From: Daun Johnson
Sent: 01 February 2021 16:41
To: Planning Scanning
Subject: FW: Important update regarding AB/109/20/HH - 32 King Street

From: Alastair Smith [REDACTED]
Sent: 01 February 2021 15:42
To: Zac Denton <Zac.Denton@arun.gov.uk>; juan.baeza@arun.gov.uk
Cc: [REDACTED]
Subject: Important update regarding AB/109/20/HH - 32 King Street

I would like to give you a quick update regarding the application for 32 King street. As you will be aware this application is being determined at the Development Control Committee on 3rd February at 2.30 pm.

I am pleased to say that there has been constructive dialogue between Mr Moore and myself, with recognition that a compromise solution is in everyone's best interest. Mr Moore has now submitted (25.01.21) to ADC revised plans for his extension.

NORTHERN ELEVATION

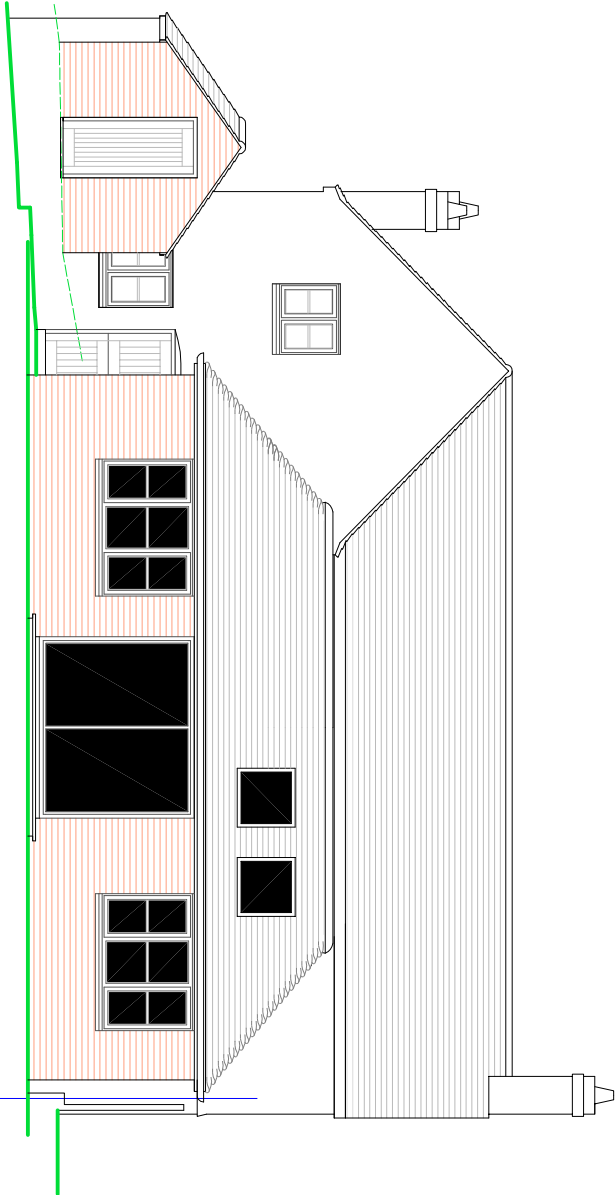
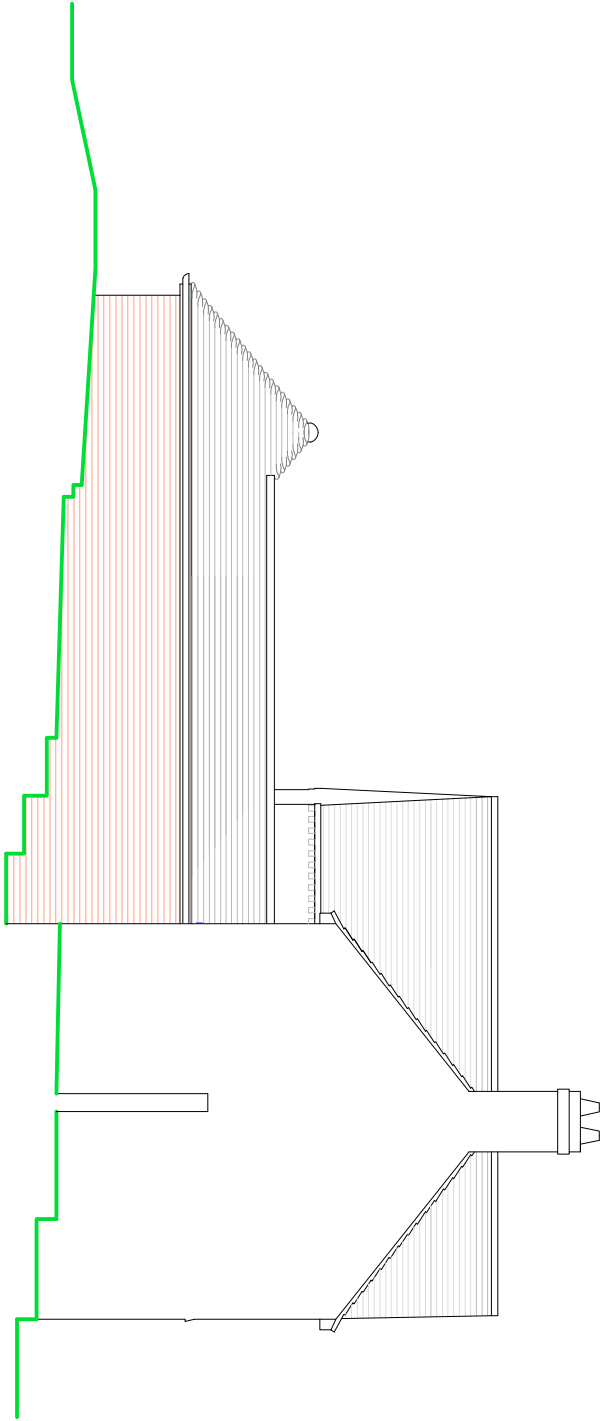
1. The revised position of the north wall of the proposed extension, approximately halfway along the proposed wall, steps away from our shared boundary line, to protect a minimum of 3 meters of beech hedgerow compared to the previous proposed plans. This is far better screening and I very much want to keep as much of the existing hedge as possible. Mr Moore assured me that every provision would be made to protect this section of the hedge during construction, including any barrier 'root' protection.

4. The visible North Wall of the proposed extension, which will not be screened by the hedge, will be faced with traditionally constructed, coursed field flint and lime mortar.
